From: Terry Tunmore [REDACTED]
Sent: 30 September 2013 13:31
To: Planning.Responses
Subject: RE: Further Information Required on Your Ref: N/A Our Ref: LY/20/13/CLP

S.
REAR (EAST) ELEV

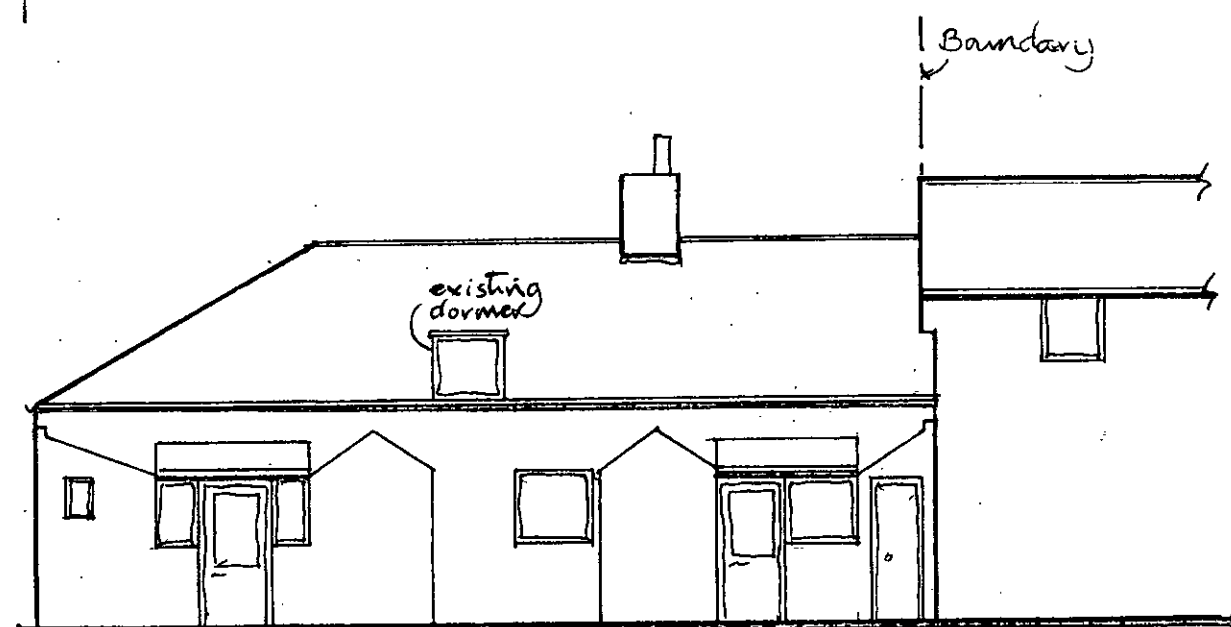
The rear floor plan and rear elevation do not accord. There are windows and doors missing on the floor plan that is being shown on the elevation. As you can appreciate, if the plans don't accord, we have no idea which plan is the correct plan. [Terry Tunmore] As this whole elevation is rebuilt I cannot see it's importance which is why it was only schematic. I will update as you request though.

LOCATION PLAN

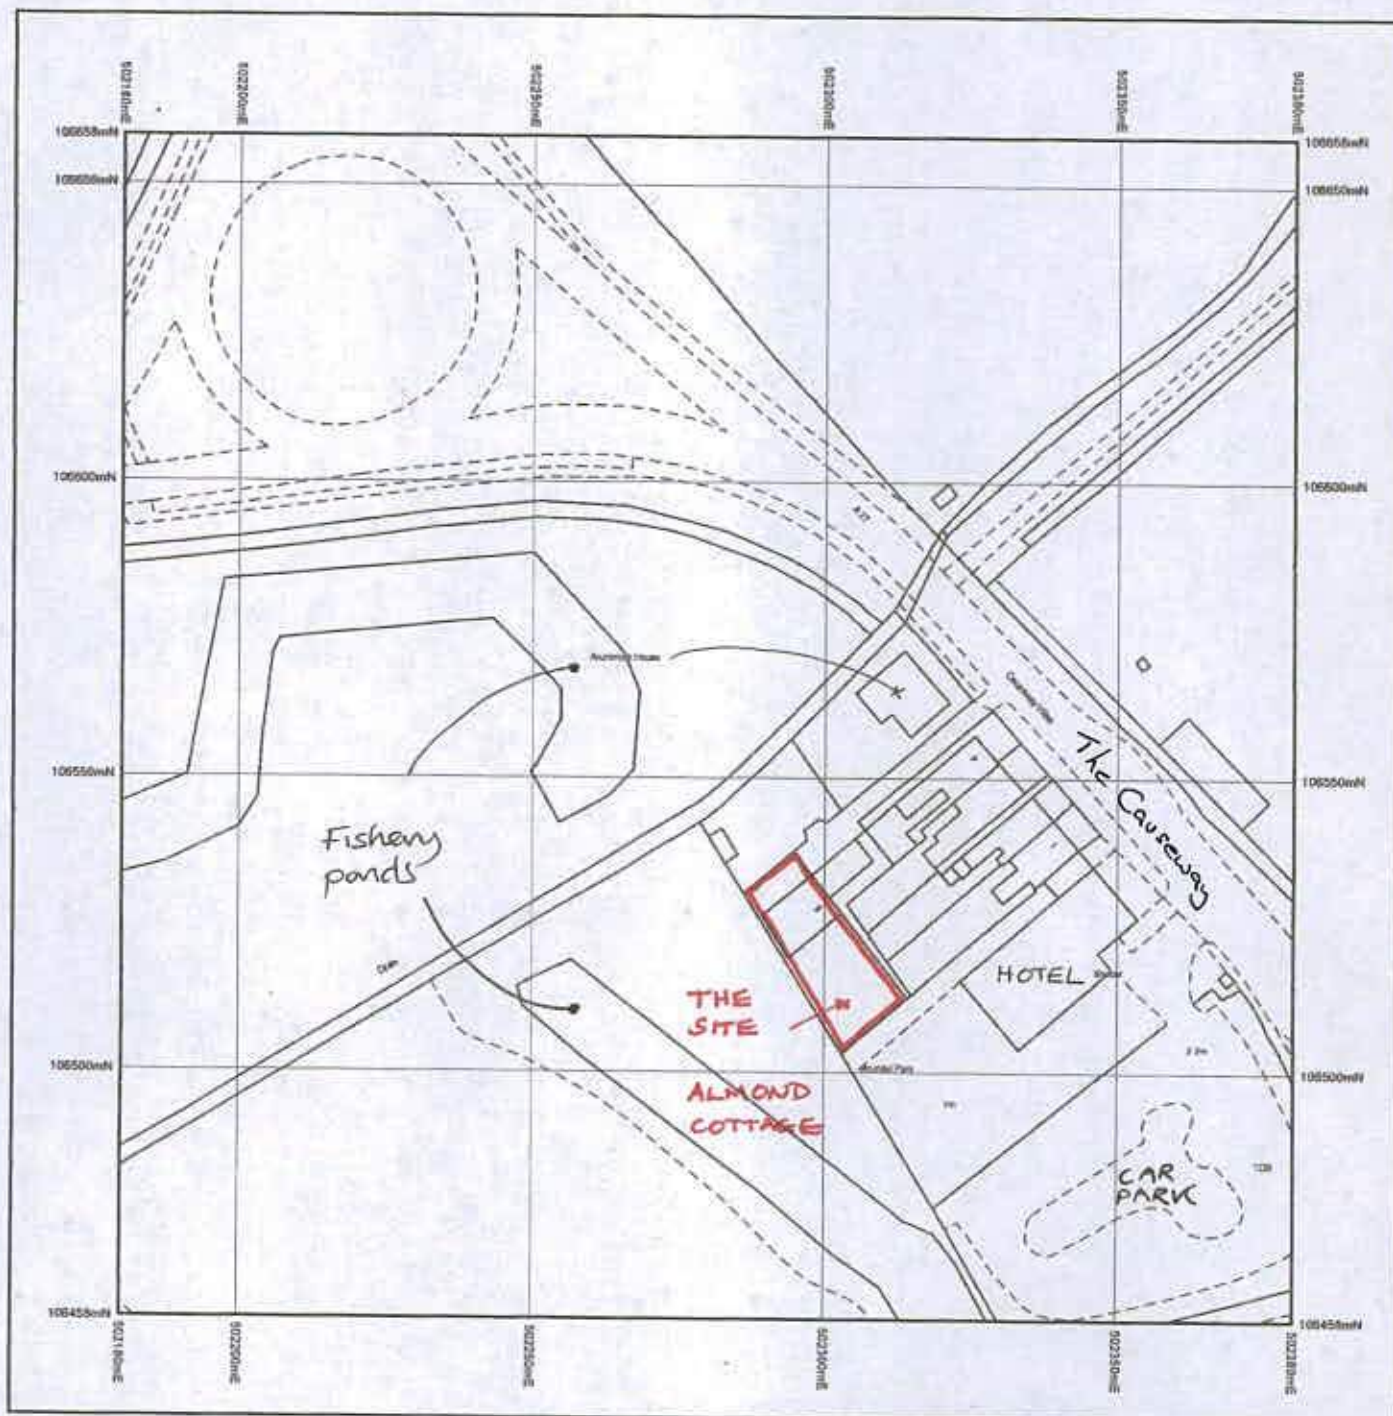
A Location plan at a scale of 1:1250 or 1:2500 (rural areas only) is required for this type of application. [Terry Tunmore] I have downloaded a 1:1250 as I assume you will not consider this a rural area. It shows little more than the 1:500 but I will present it accordingly.

In response to this letter, we believe we did deliver by hand 3 copies of a 1:500 location plan, perhaps you can re-check. We can provide a 1:1250 scale for you although I thought it was specified that 'either' was required which is why we went for the larger scale.

SITE PLAN

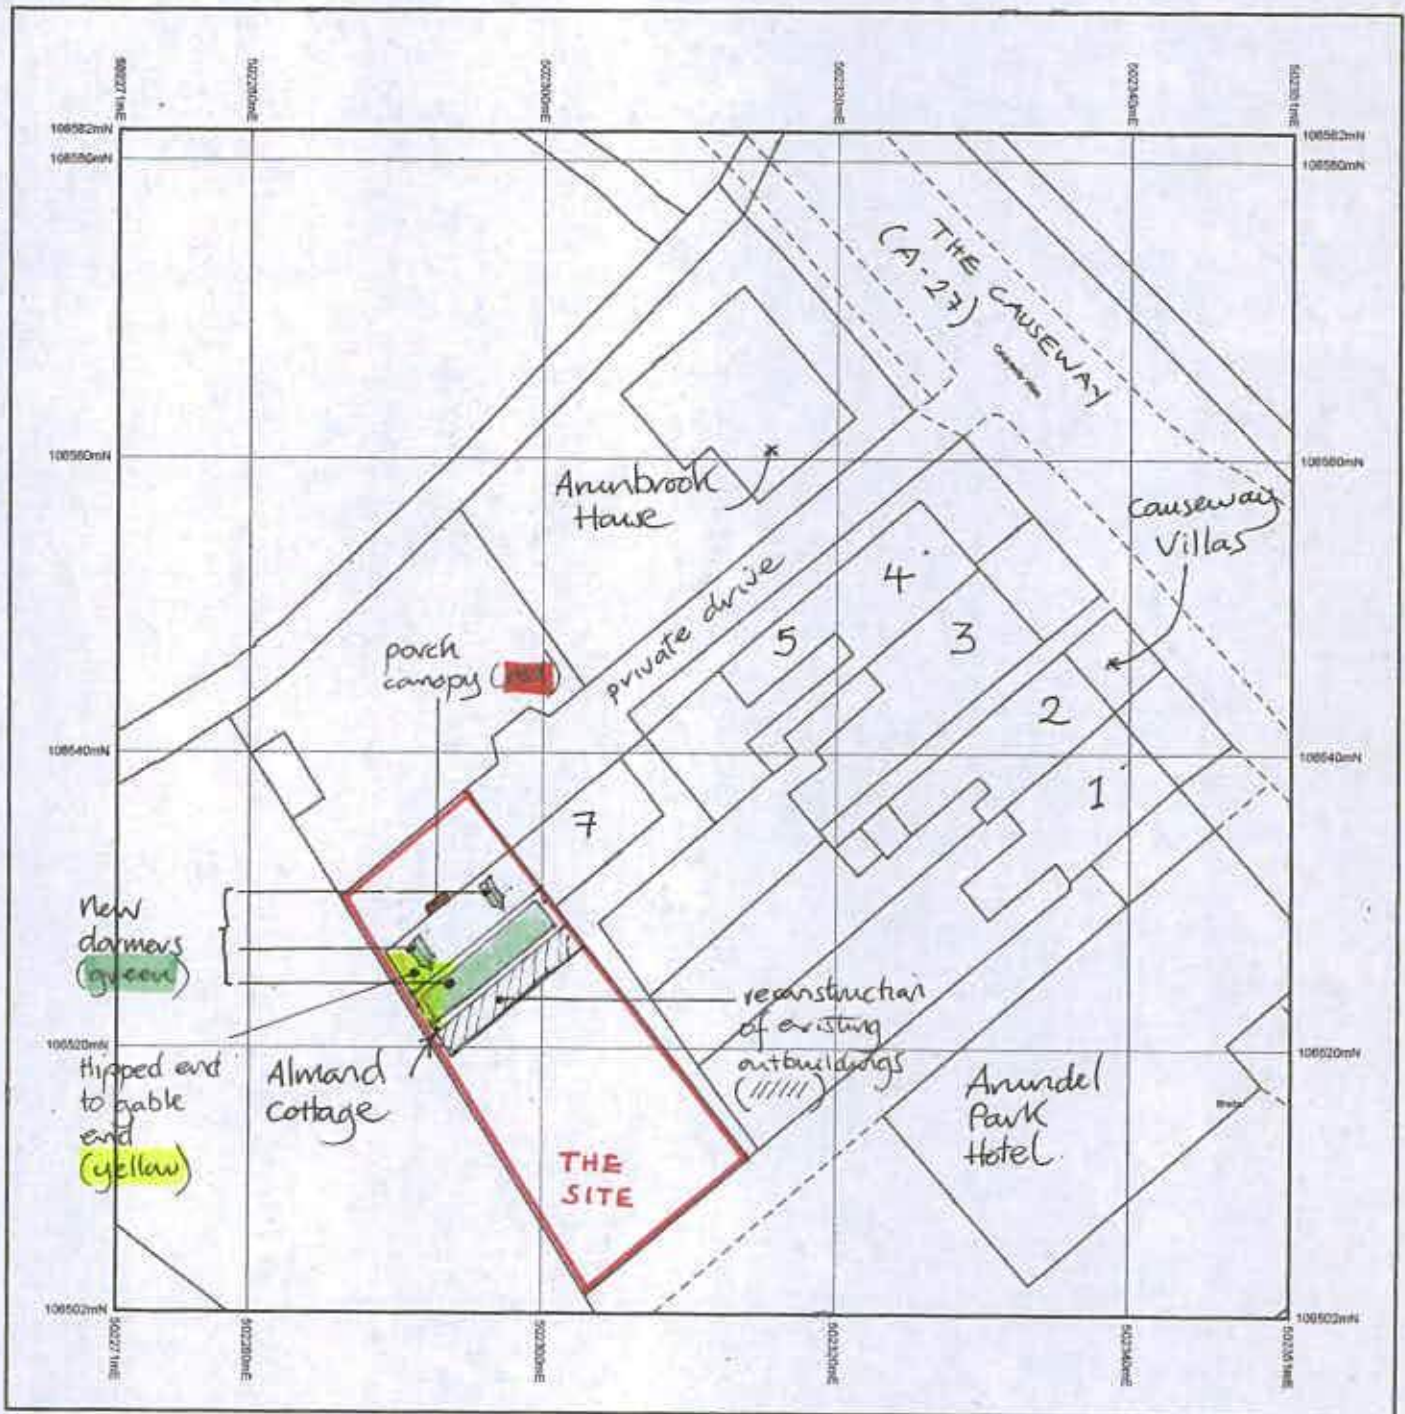
The plan you gave me at a scale of 1:500) is correct in the scale, however, the proposed works need to be clearly highlighted. [Terry Tunmore] I see, I will do my best! However, direct comparison of the plans [as you clearly do] will easily identify this information.

EXISTING GROUND FLOOR PLAN

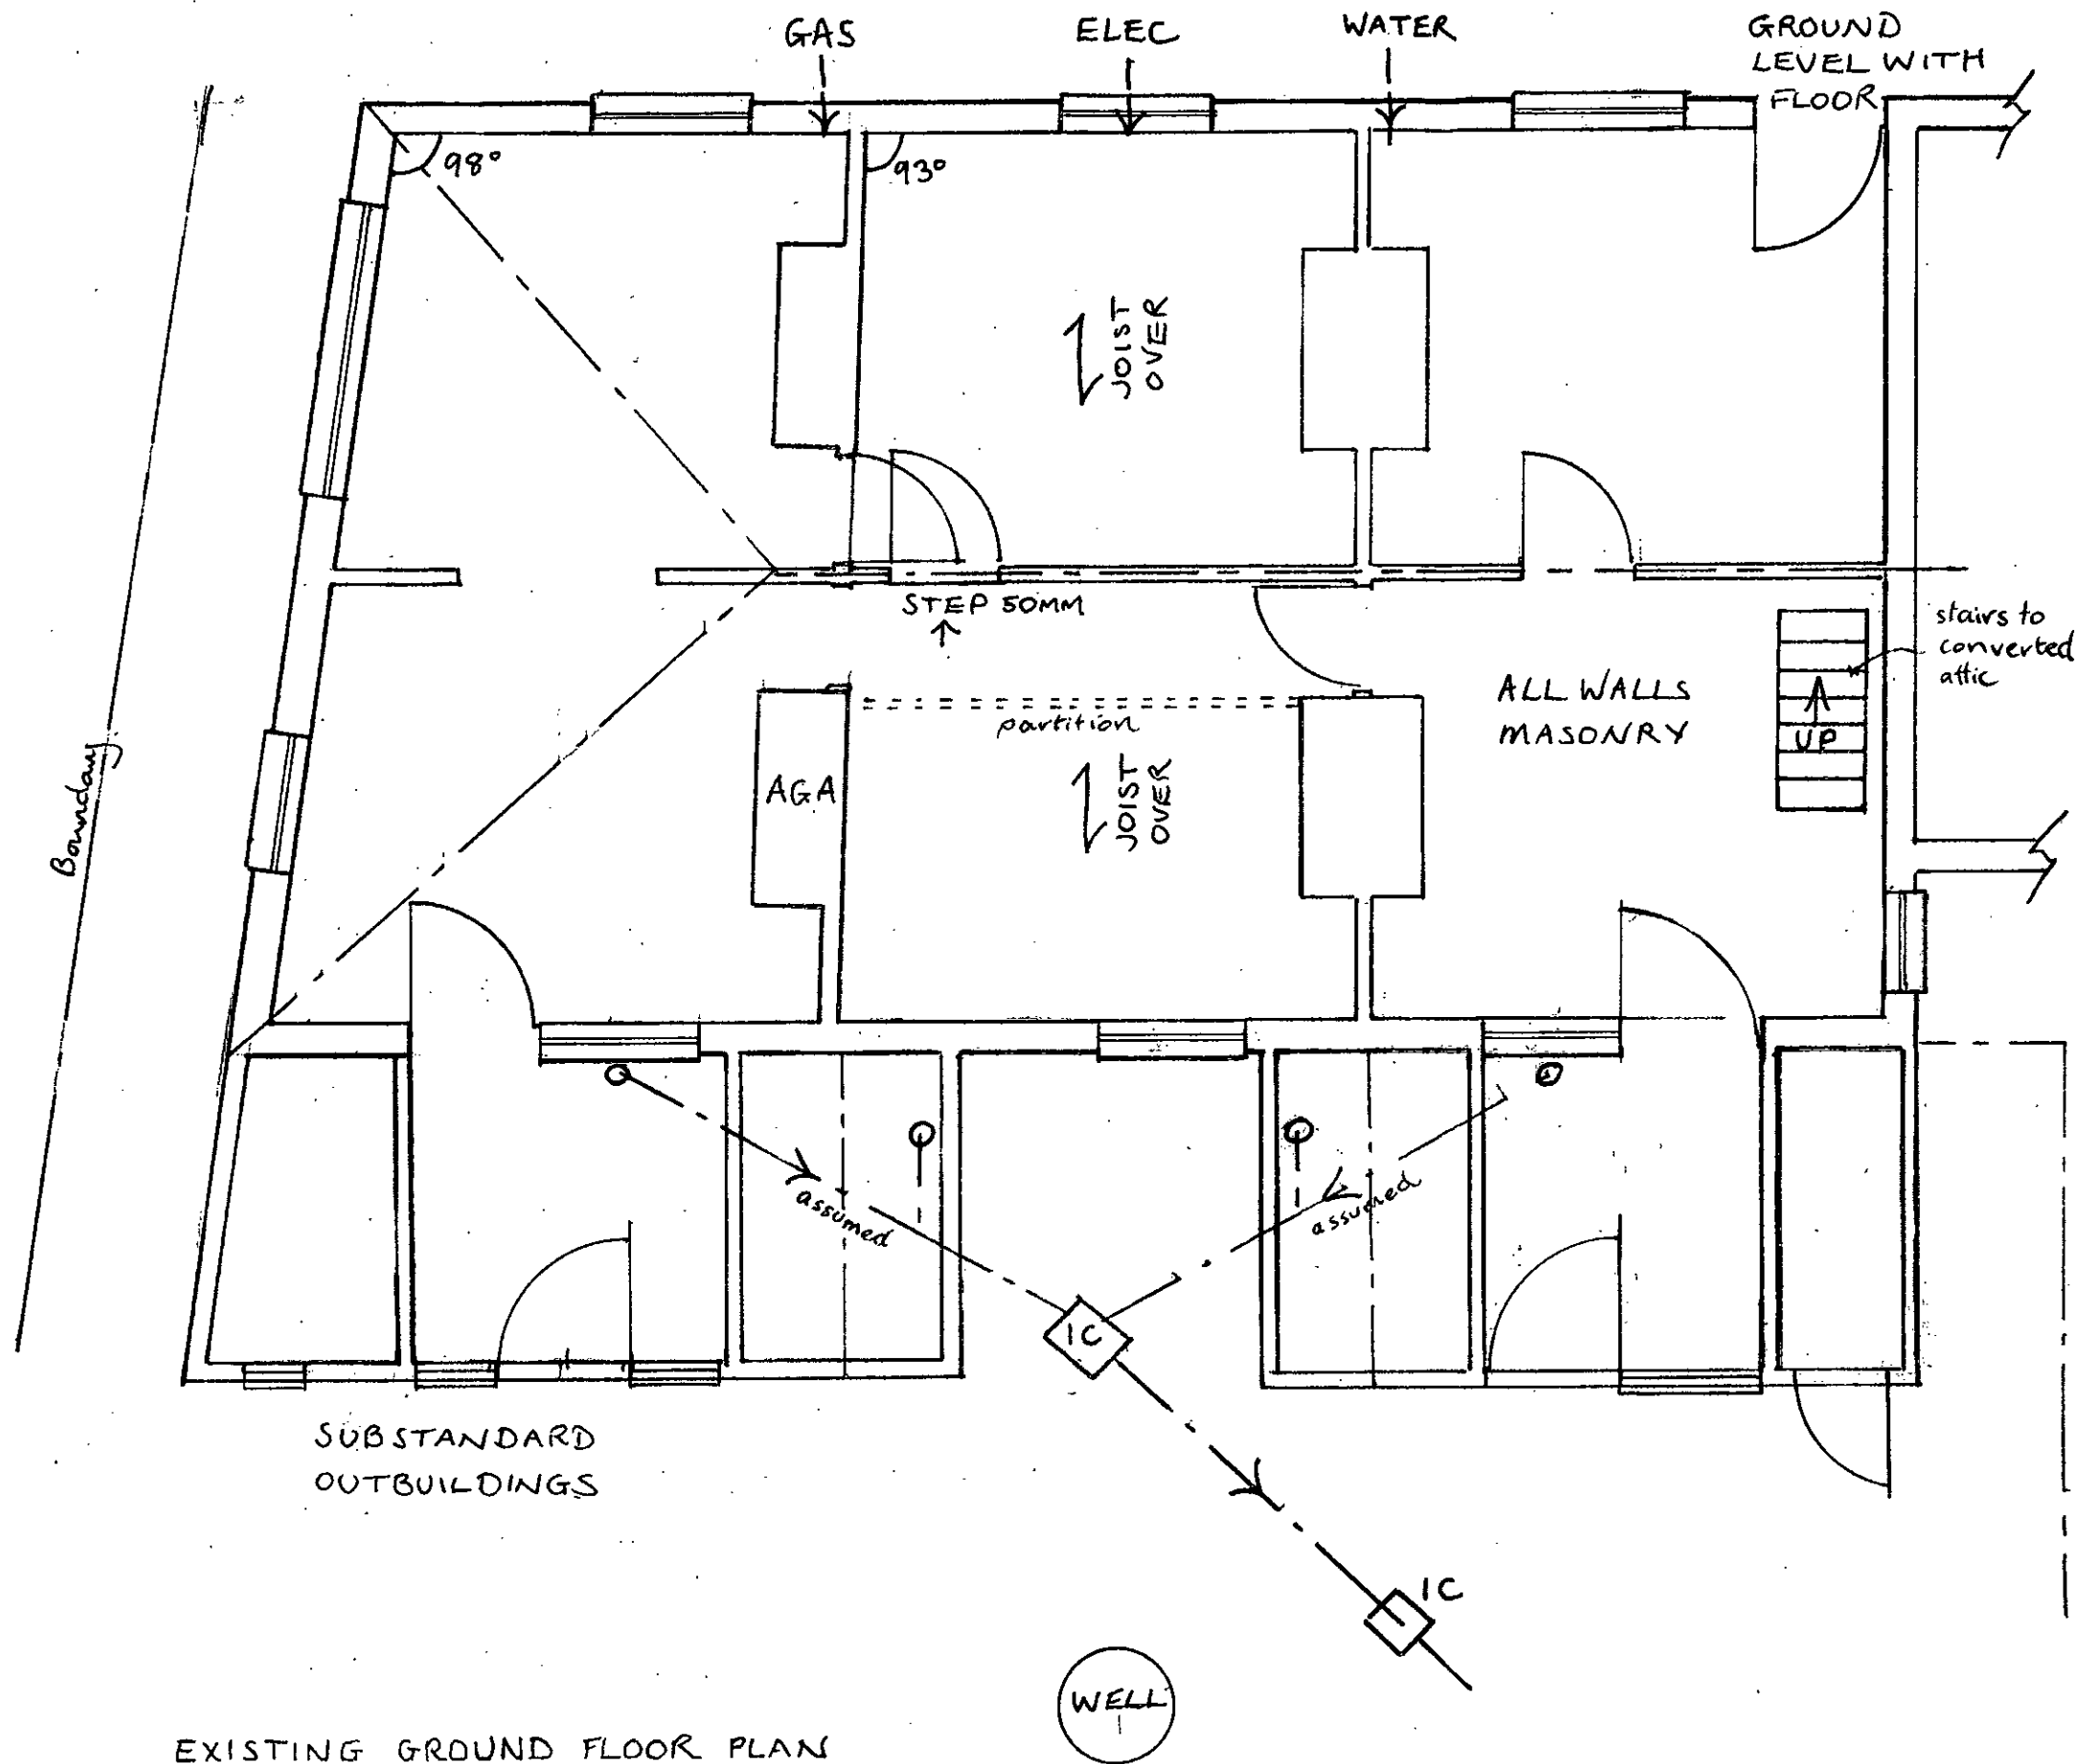
Regarding the existing plan/elevation discrepancy can you be more specific? Is it that the windows on the rear elevation are not shown on the plan?
